# Cottam Solar Project

## Schedule of Changes (Deadline 4)

PINS Reference: EN010133  
Document Reference: EX4/C8.1.7\_C  
The Infrastructure Planning (Examination Procedure) Rules 2010  
Rule 8(1)(k)

Figure number Date
11 **06/10/2022**

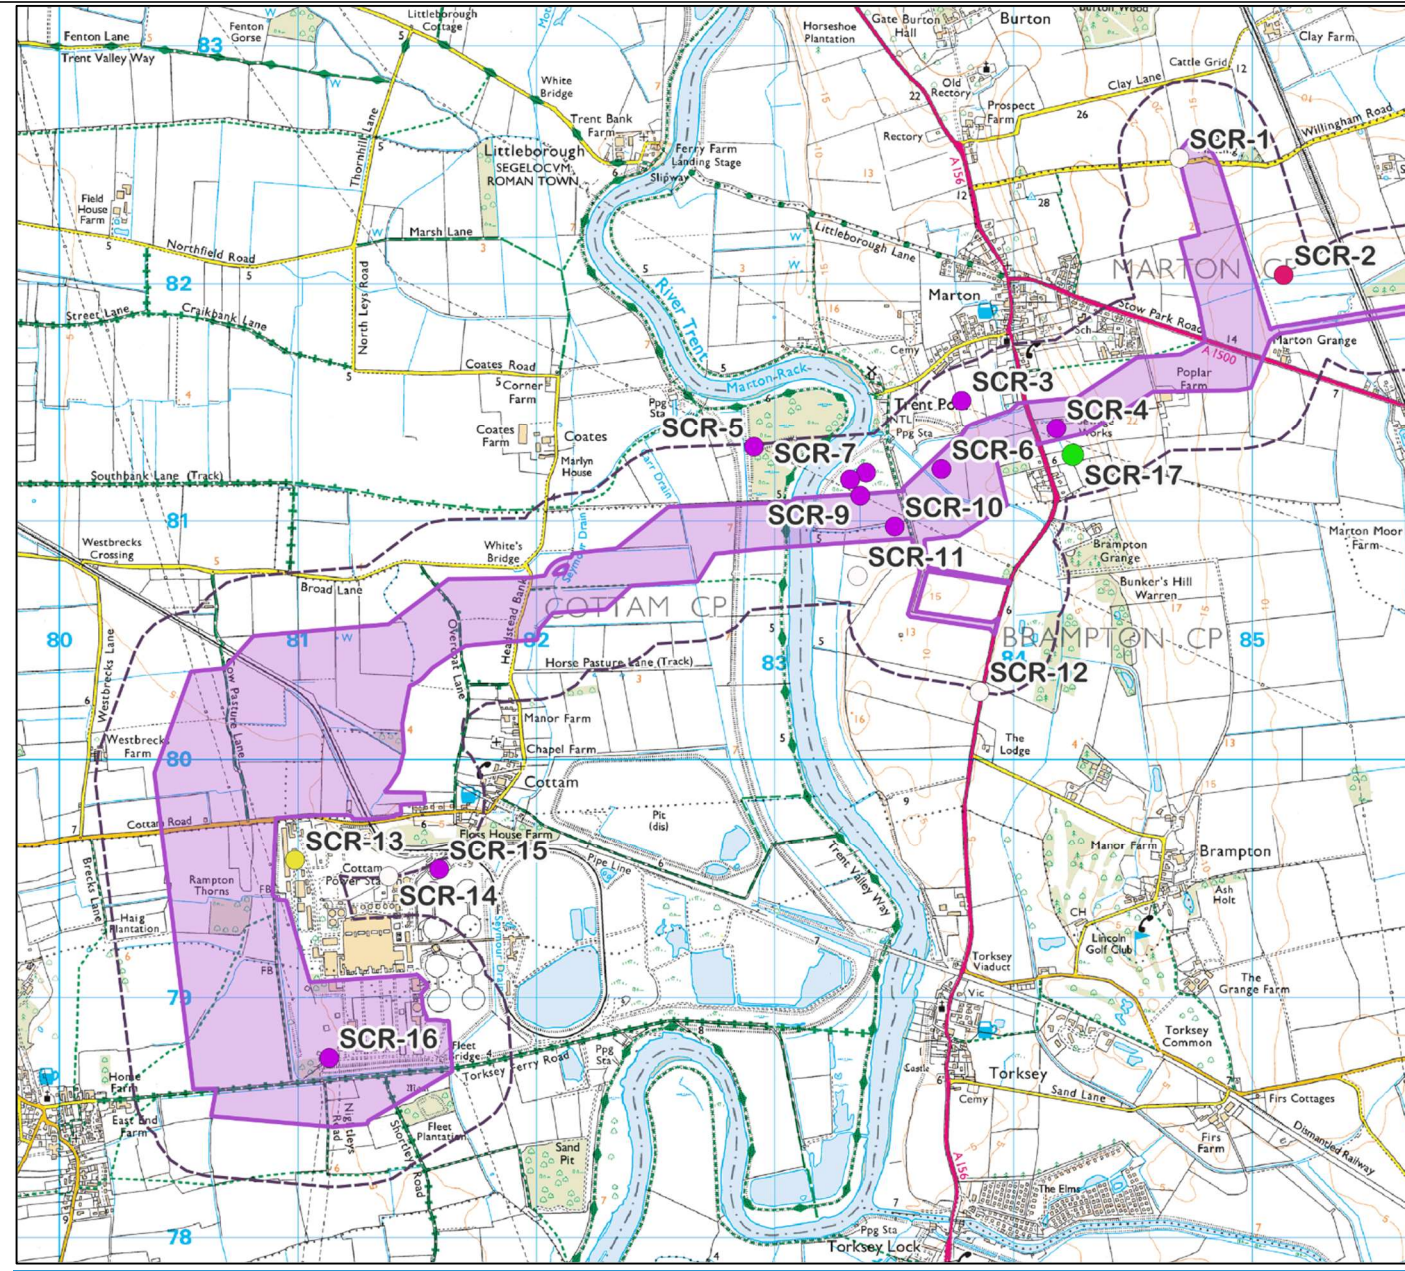
C6.3.9.7 Great Crested Newts Survey Report	[APP-084]	Revision A [EX1/ C6.3.9.7_A]	Deadline 1 17 October 2023	Paragraphs 2.2.11, 4.1.6 and Figure 11, added; Paragraph 2.2.22 deleted and Paragraphs 3.2.6, 4.1.2, 4.1.5, 4.1.7, 4.2.4 and Tables 7, 12 updated to include 2023 Great Crested Newts Survey.	To provide information on the likely presence or likely absence of Great Crested Newts for 6 additional ponds along the cable corridors where access had not been previously arranged and of a further three ponds which were previously found to be dry.
C6.3.14.2 Construction Traffic Management Plan	[APP-135]	Revision A [EX1/ C6.3.14.2_A]	Deadline 1 17 October 2023	Construction Traffic Management Plan updated to take equestrians and reinstatement of private roads into account.	ExA Request ISH1 and to address the British Horse Society's Relevant Representation [RR-023].
